**Coastal Grove, 1 Survey Street Lennox Head (MP06_0002)
Response to Submissions**

I refer to your letter of 4 December 2006 regarding submissions to the public exhibition of the Environmental Assessment for the proposed residential subdivision and associated works at 1 Survey Street Lennox Head.

FIGURE 2

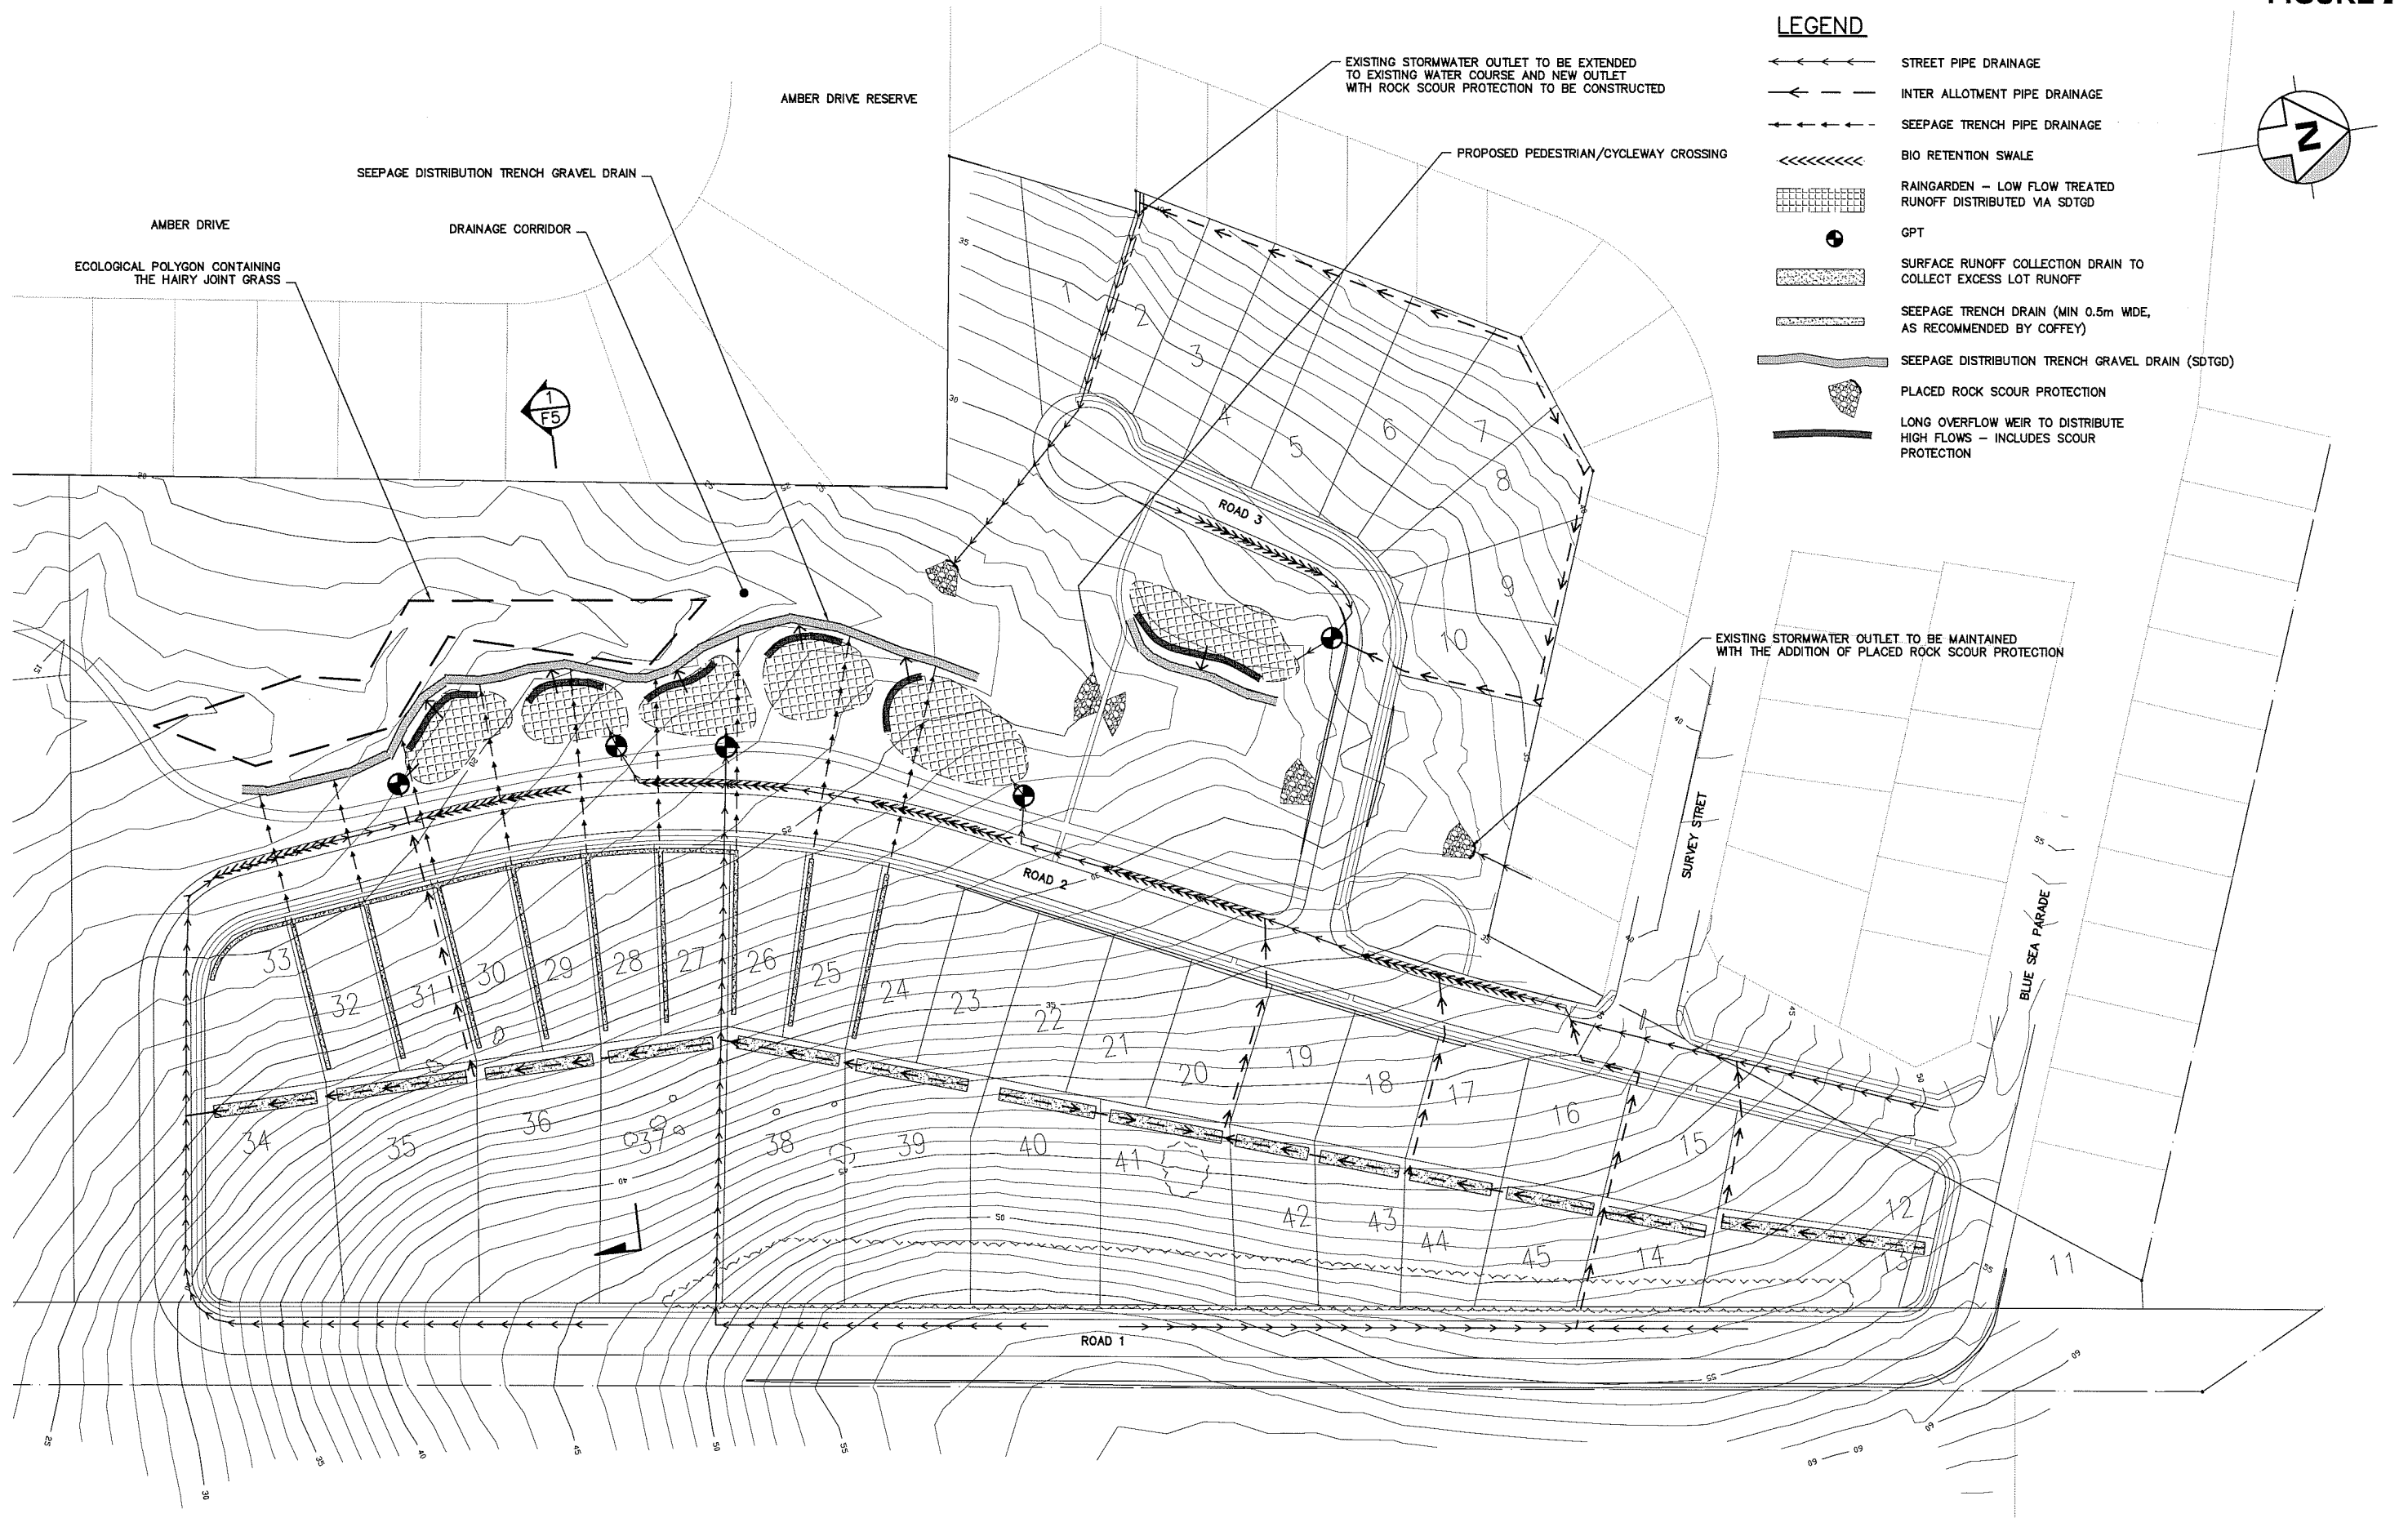
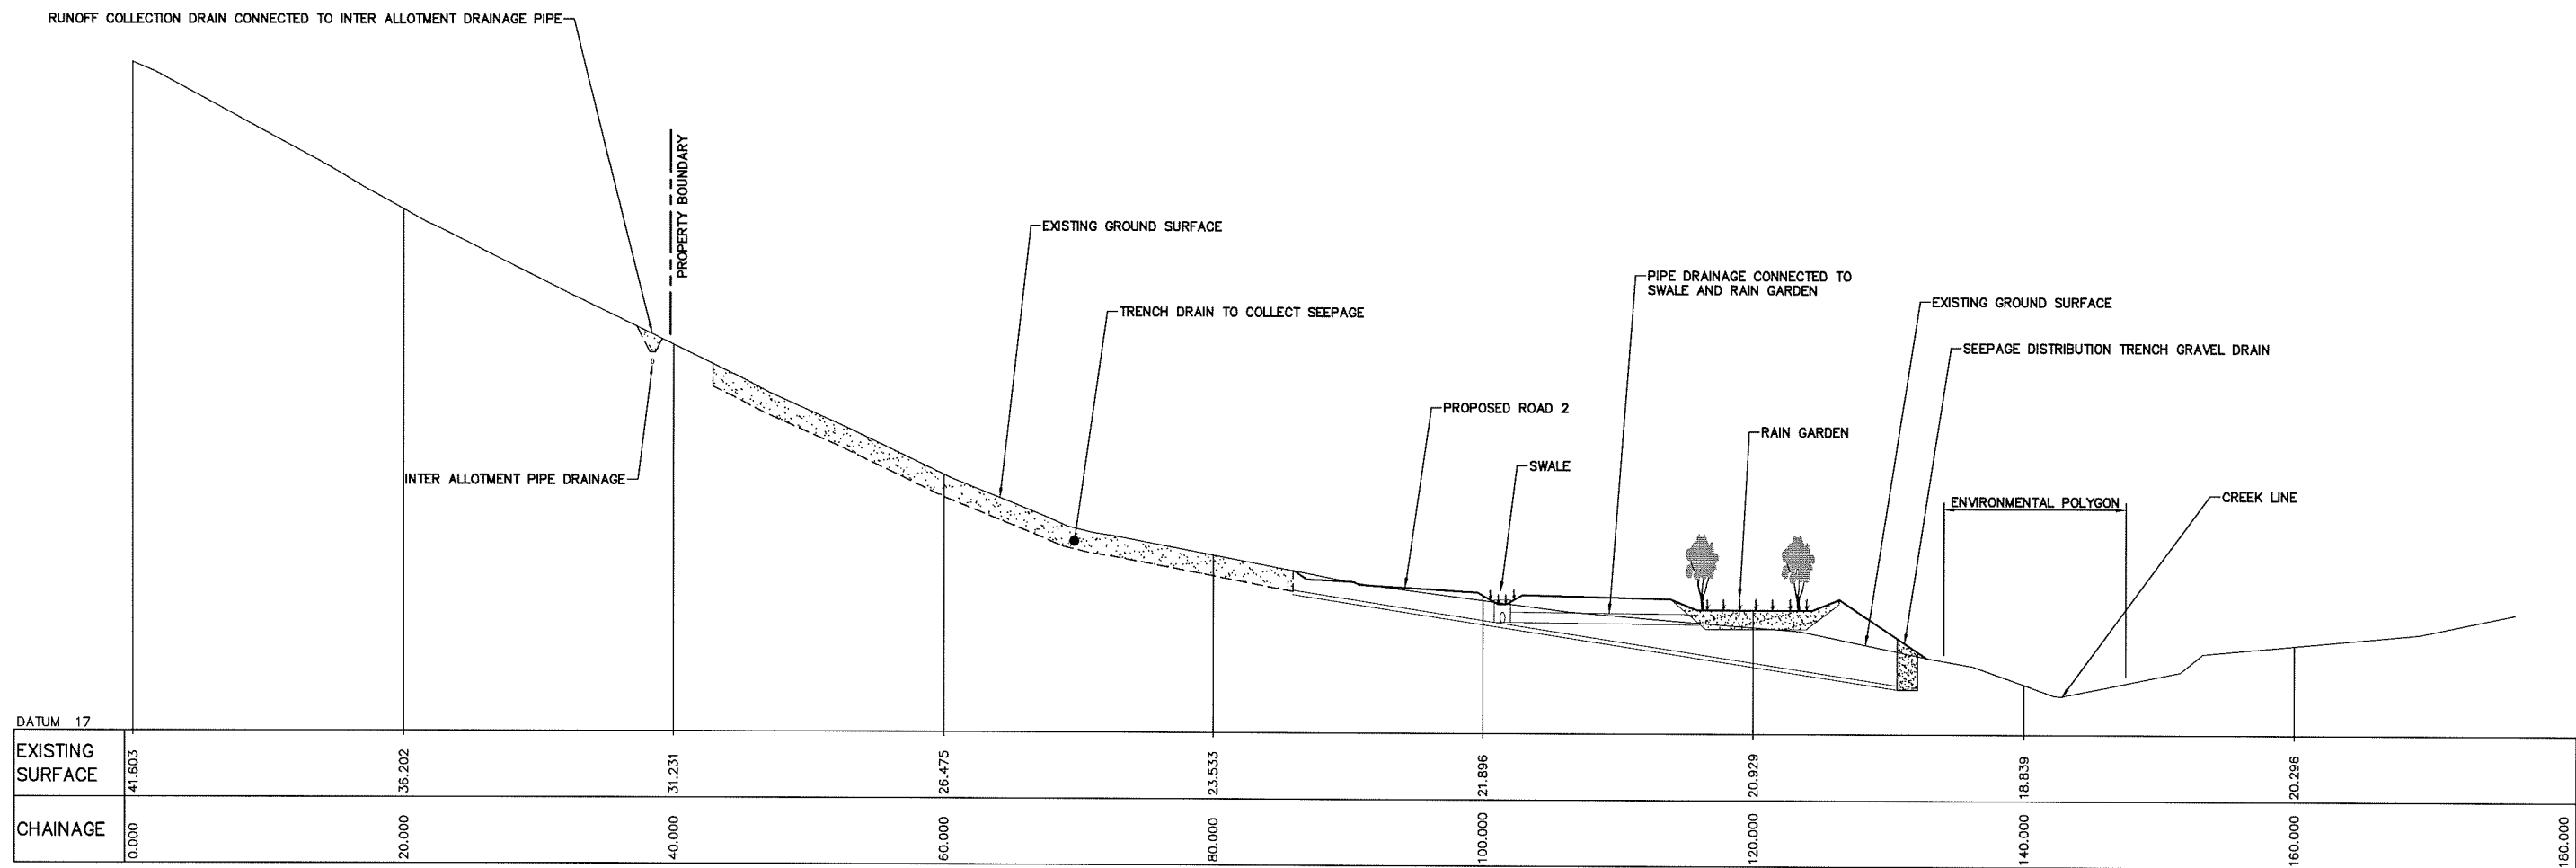
7. The high flow discharge from the raingardens has been clarified in Figure 2. Each pond would be independent with flow over a long discharge weir to distribute the flow over a wide area and provide scour protection.

- the seepage will be collected in trench drains and will be separate and independent of the street drainage system. The drainage pipes from these trenches will direct seepage to the seepage distribution trench gravel drain (refer Figure 2). This trench will permit gradual and distributed seepage of this water along the creekline to replicate the boggy nature experienced in the existing conditions. In this way, the boggy nature of this area adjacent the creekline will be maintained. This is the dominate hydrological process affecting the Hairy Joint Grass and the hydrology experienced by the grass will not be changed;
